Application No: A/186/24/CLP

Site Address: 1 Lansdowne Close Angmering BN16 4JN

Description of works: Lawful development certificate for a proposed extension and roof alterations to an existing craft-room / outhouse to create a habitable space.

Proposed side elevation Plan:

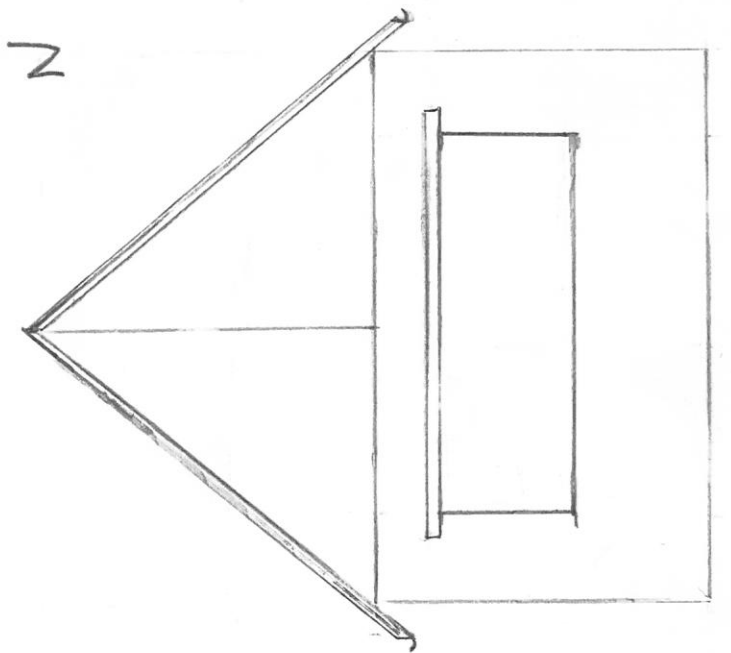
- a) the additional build is close to the boundary of surrounding properties and may be deemed to be overbearing.
- b) the poor quality of the presented drawings do not show in mm the height and other measurements as required for such an application, thereby making it difficult to judge the full intent.
- c) the proposed extension to the workshop and its intended use will change this to a residential Class C3 unit.
